Council Reference: DA11/0565.08 LN8987
Your Reference: MP08_0194 MOD 8

Development Application MP08_0194 MOD 8 (Council Reference DA11/0565.08) - amendment to Kings Forest Project Application)

ROAD HIERARCHY
AND STAGING PLAN
SHEET 2

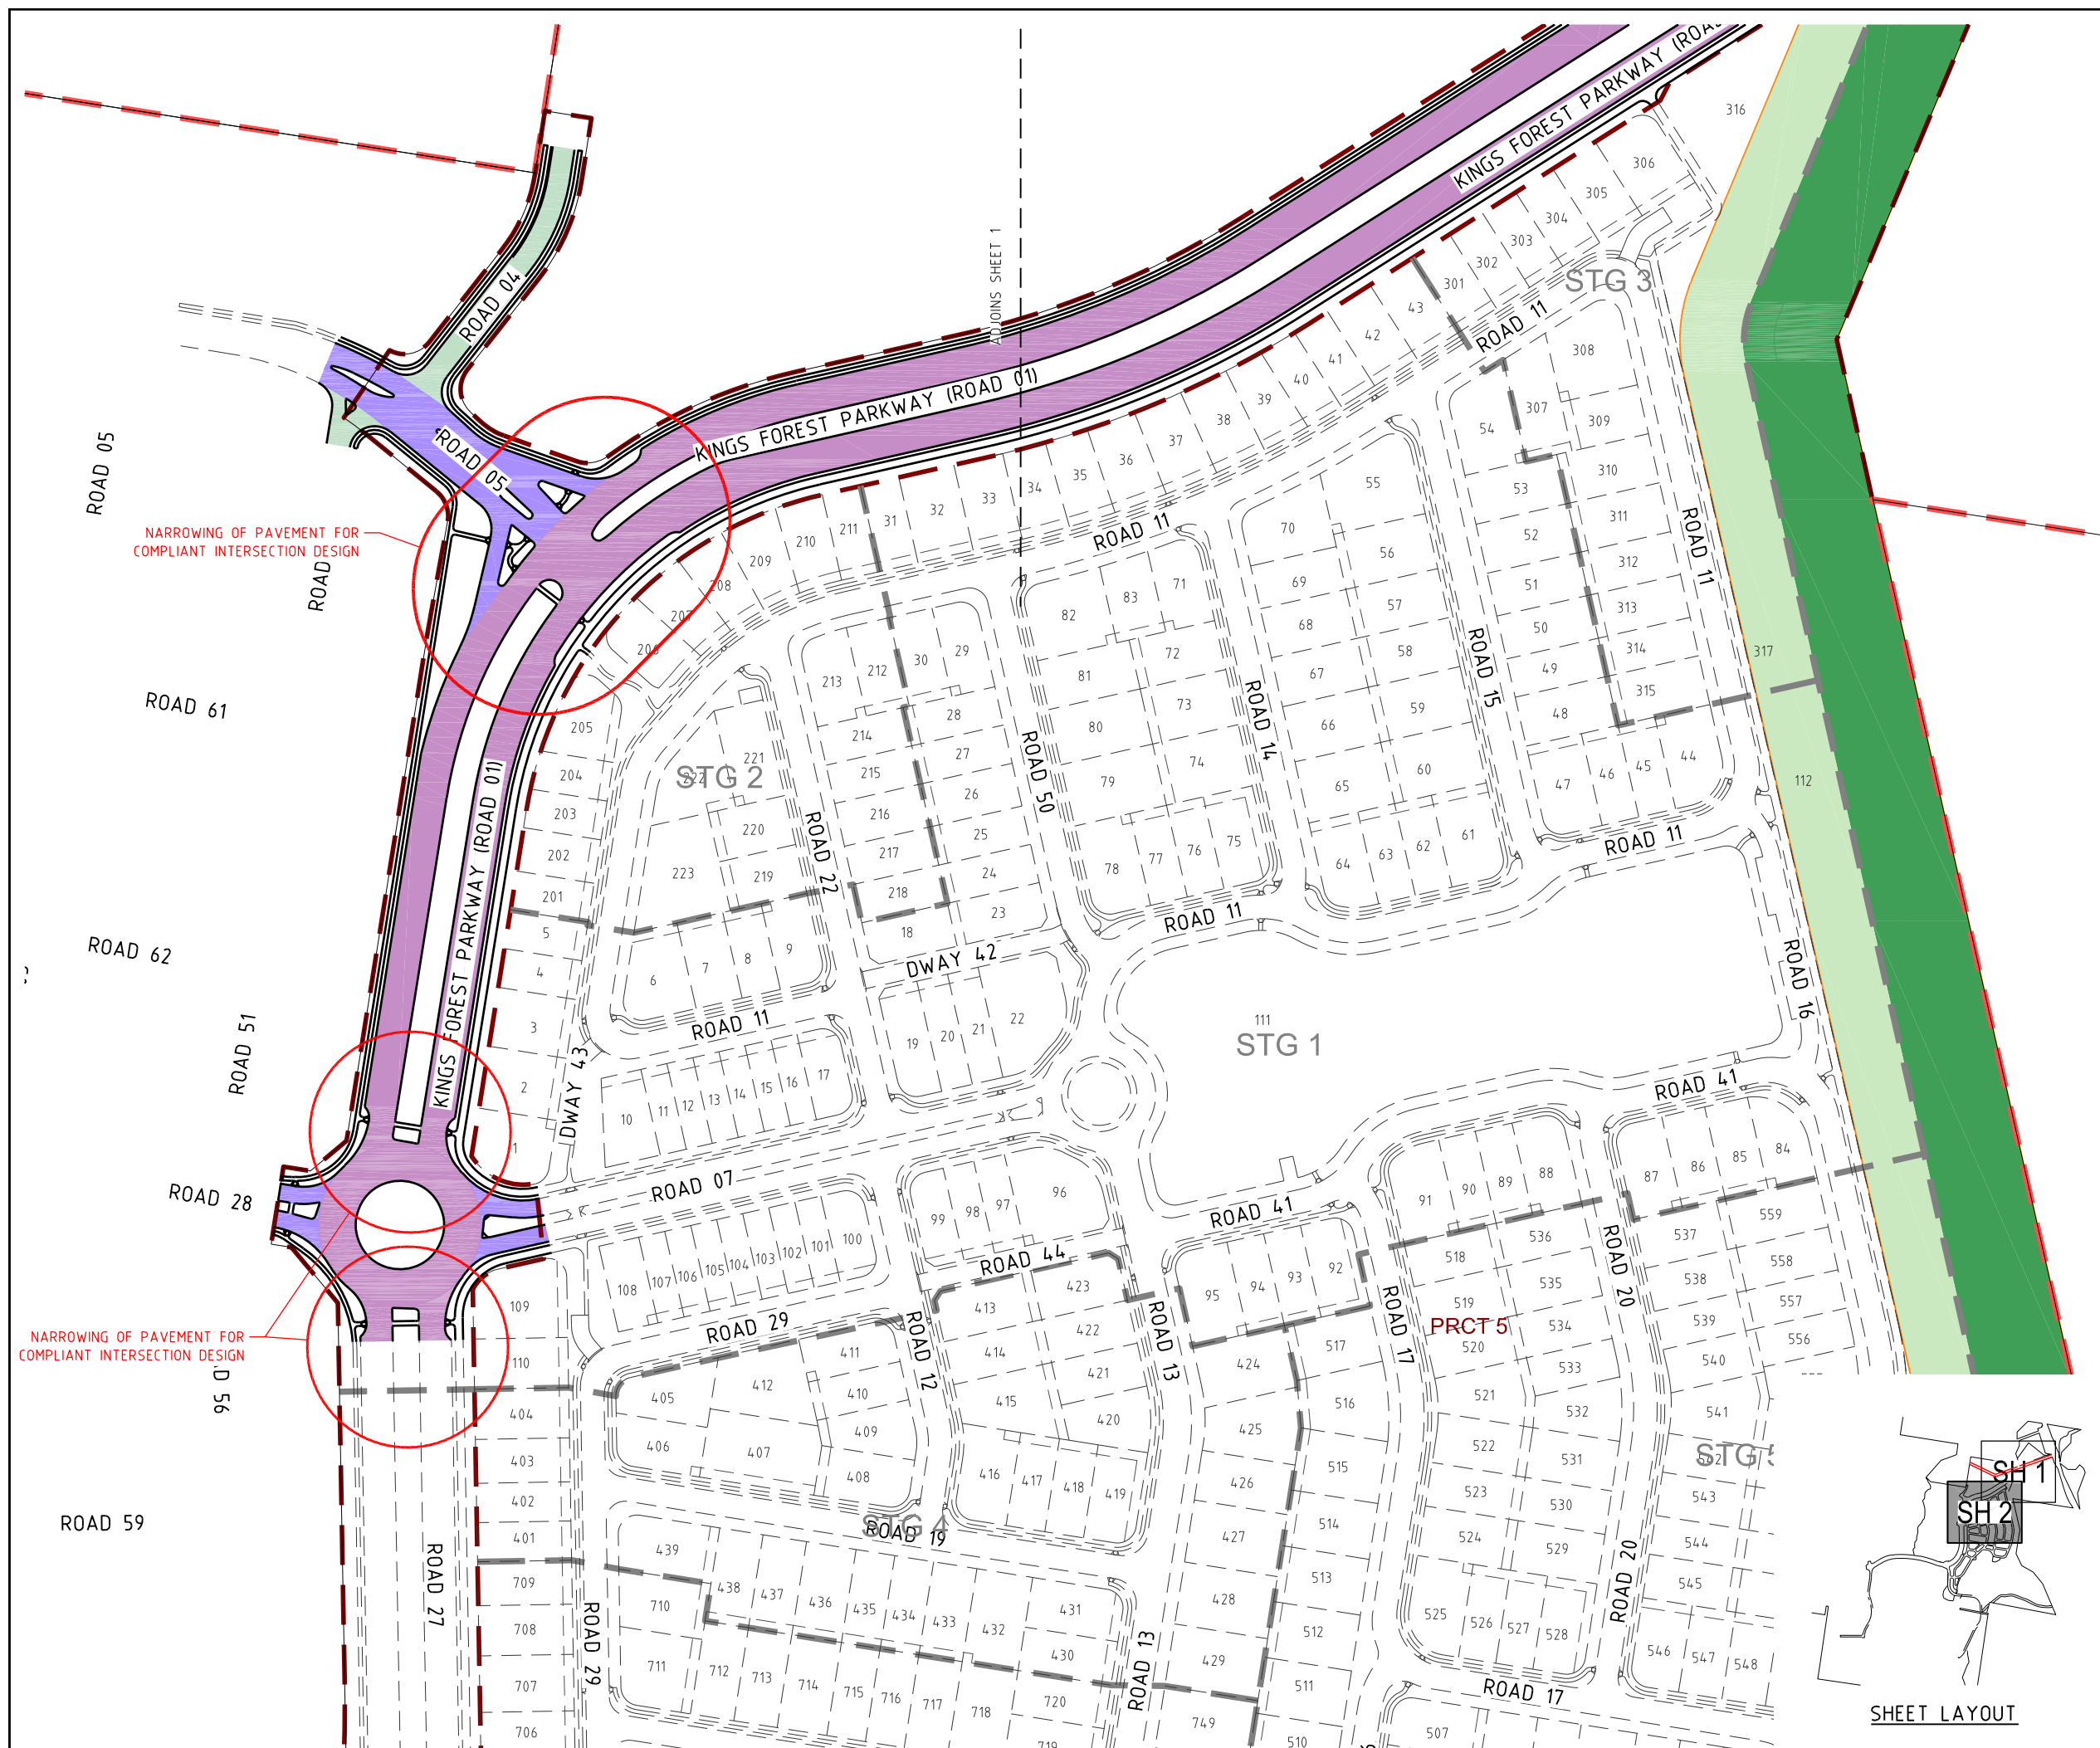
Request 3 – Amend Condition 23(6) relating to Kings Forest Parkway Road Pavement Width to less than 9m (7m) in certain locations as shown below:

However, Council would like the applicant and the Department to have additional consideration to imposing additional conditions of consent to ensure water and sewer infrastructure will be adequately catered for in these reduced areas as follows. Some suggested additional conditions are as follows under the following headings:

Response 3: The revised condition wording as duplicated below is consistent with previous correspondence with Darryl Anderson and Mortons Urban Solutions.

- 23 (6) Kings Forest Parkway road carriageway is to be constructed to a minimum pavement width of 9m from the entry with Tweed Coast Road through to proposed Road 9, with the exception of those sections of Kings Forest Parkway, including intersections that conform with Austroads Standards, shown on Drawing No. 12301-SK-122, Amendment A, Morton Urban Solutions, 29 June 2018, and Road Hierarchy and Staging Plan, Drawing No. 12301-EMAW-005 and 006, Rev A – Mortons Urban Solutions which shall have a minimum pavement width of 7m. These details are to be provided on an application for a Construction Certificate."**

- # Prior to Construction Certificate for each stage, the developer shall demonstrate clearances between proposed sewerage infrastructure shall meet the minimum clearances between sewers and other underground services as outlined in WSA02-2014 Table 5.4.
- # Prior to Construction Certificate for each stage, the developer shall demonstrate clearances between proposed water supply infrastructure shall meet the minimum clearances between water mains and other underground services as outlined in WSA03-2011 Table 5.5.
- # Prior to Construction Certificate for each stage, the developer shall demonstrate minimum cover over proposed water supply and sewerage infrastructure shall meet the minimum cover over pipelines as outlined in TSC Development Specification D15 Table 1.
